Carriage Lane Duplex Lot #2
Project Name/Description

RE: Applications for Carriage Lane Duplexes, Lots 1 and 2

Upon review of the site plans, the City's Planning Division has the following comments:

Drawing Name:	Lot 2 Lot Layout and Utility Plan
Project:	CARRIAGE LANE

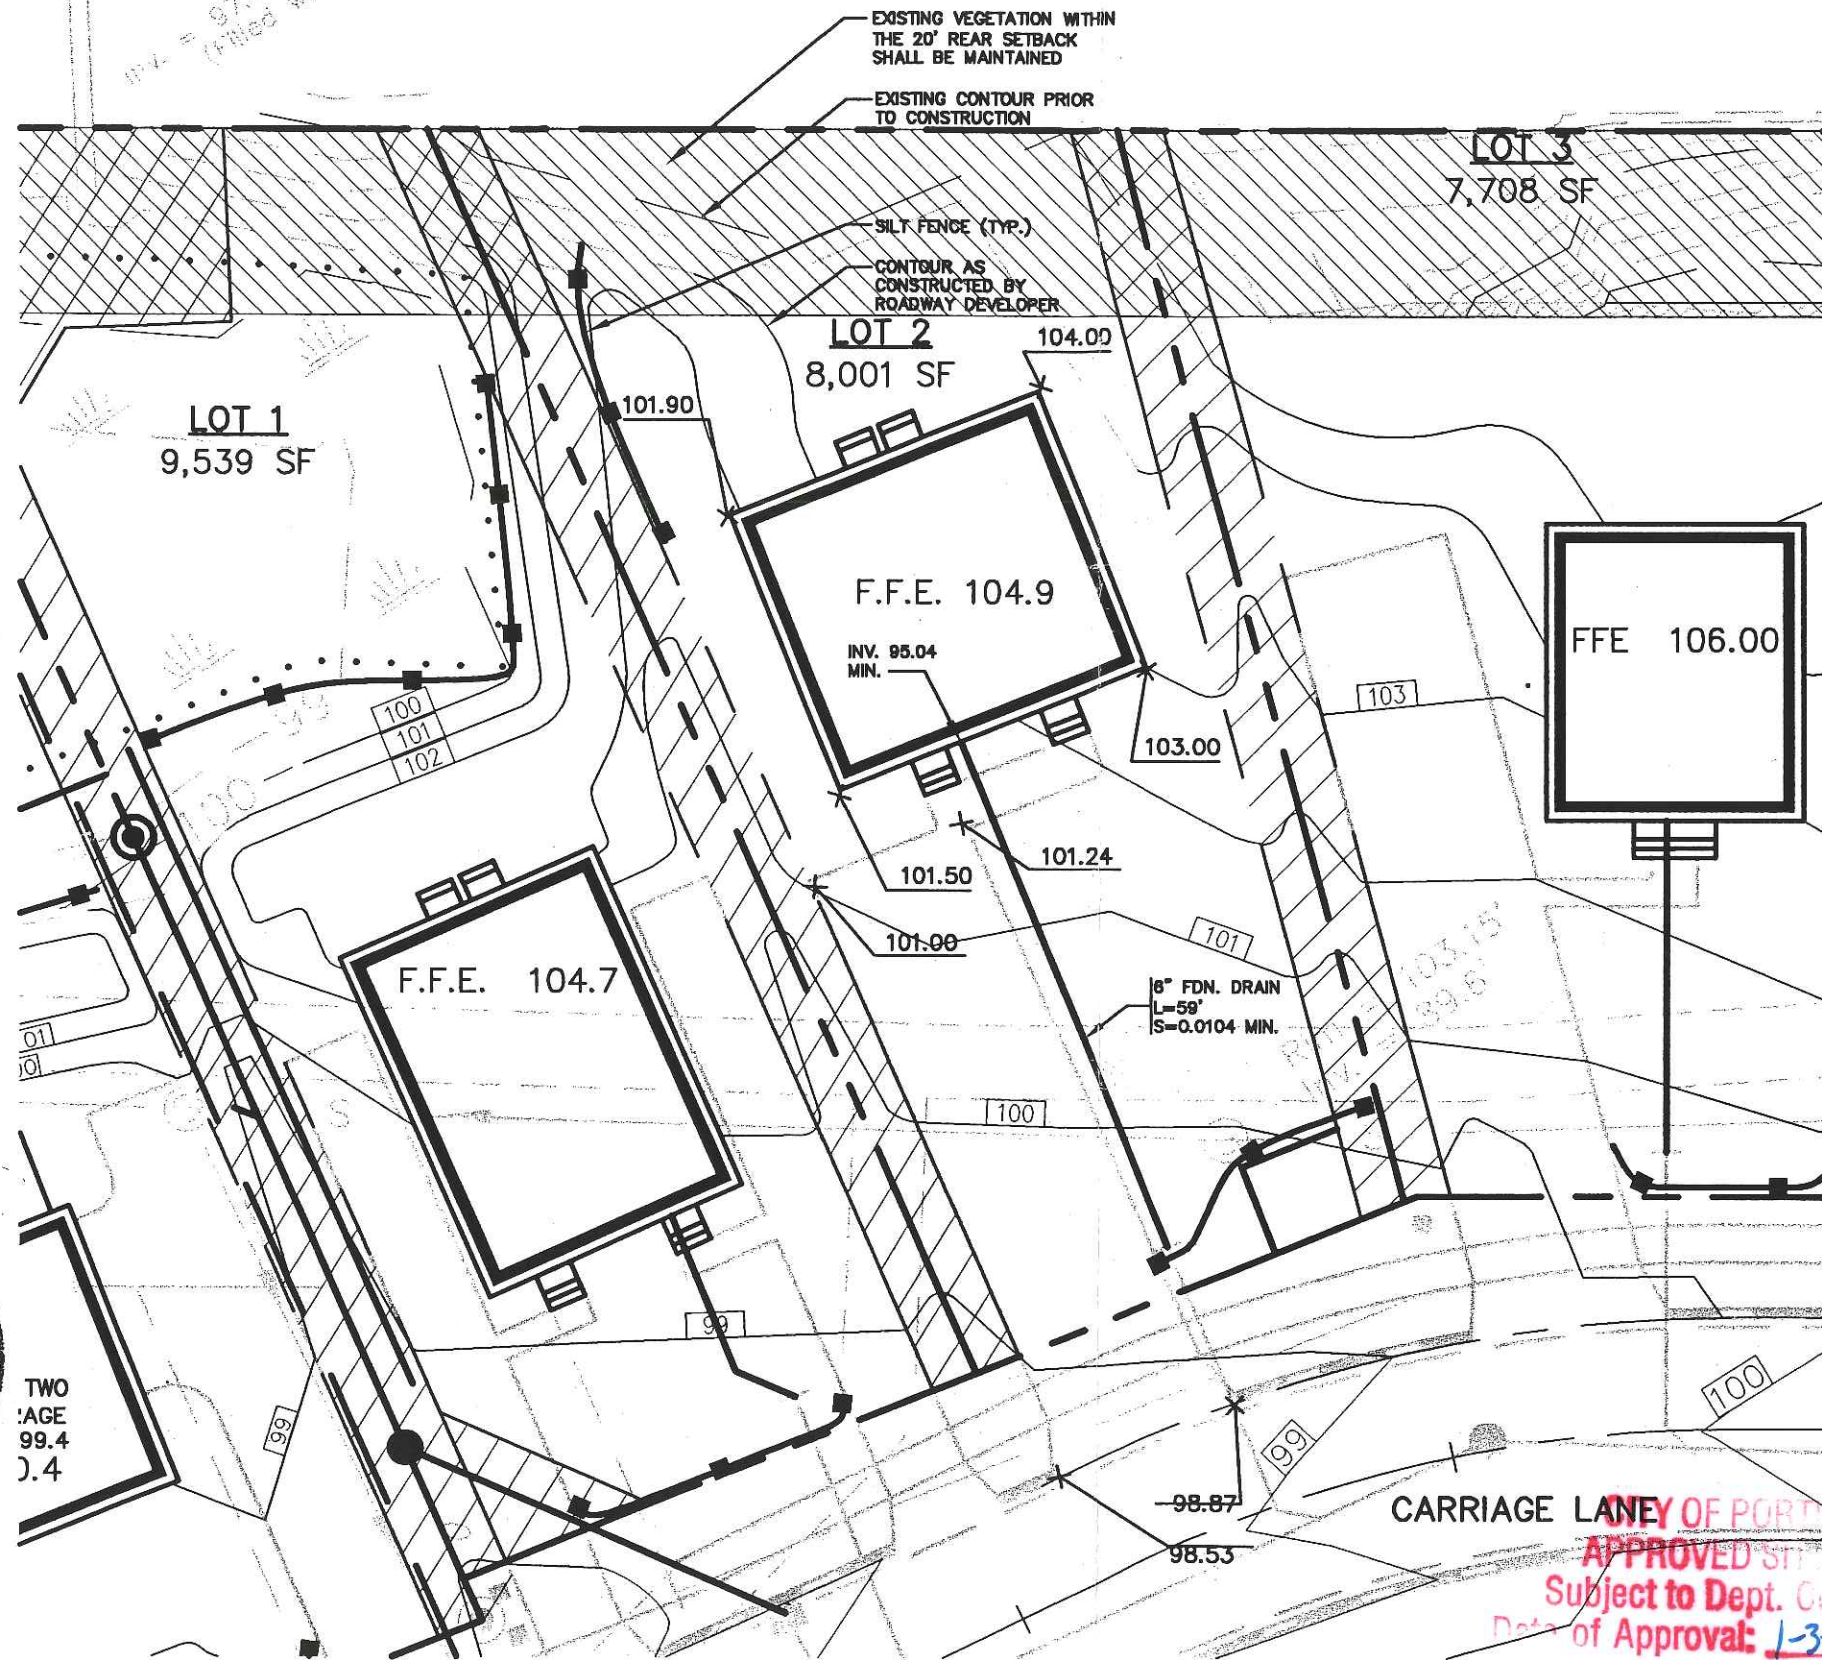
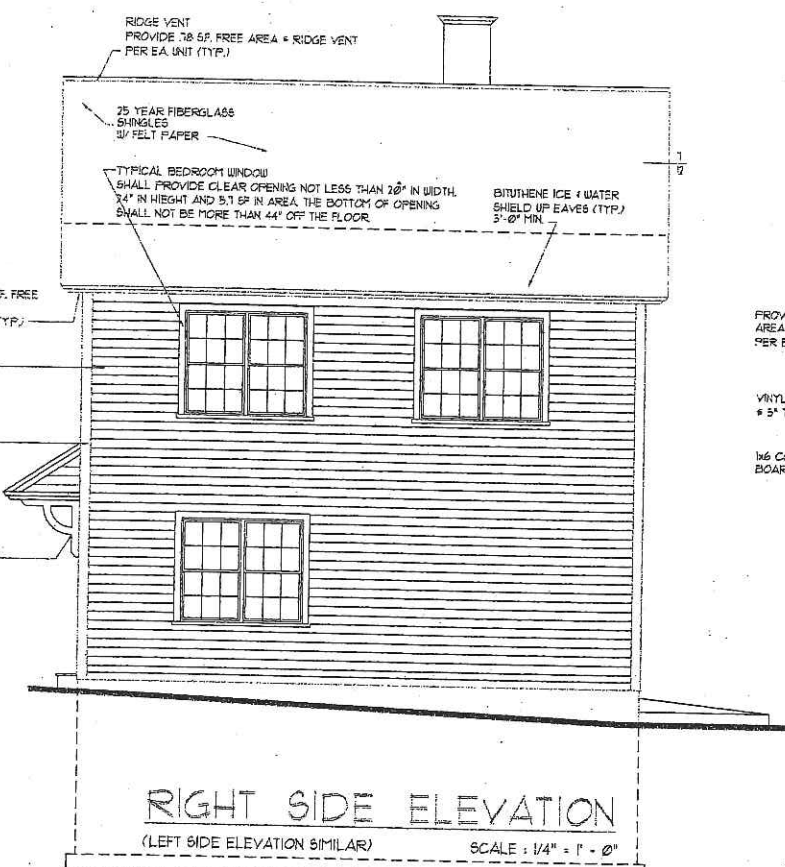
1. Lot #1:
 - a. The proposed easement shown in the front/left portion of the lot has not been finalized by the developer. An amended subdivision plat is needed for the Planning Director's signature, then it needs to be recorded at the registry of deeds. Also, a mylar and 7 paper copies of the recorded version then must be delivered to the City.
 - b. The porch/stairs and the site plan do not match.
 - c. The scaling appears to be off.
2. Lot #2:
 - a. There are a number of lines on sheet #1 that have no meaning. Please label or remove them.
 - b. The porch/stairs and the site plan do not match.
 - c. The scaling appears to be off.

Please submit 4 copies of (each lot) revised plans to my attention.
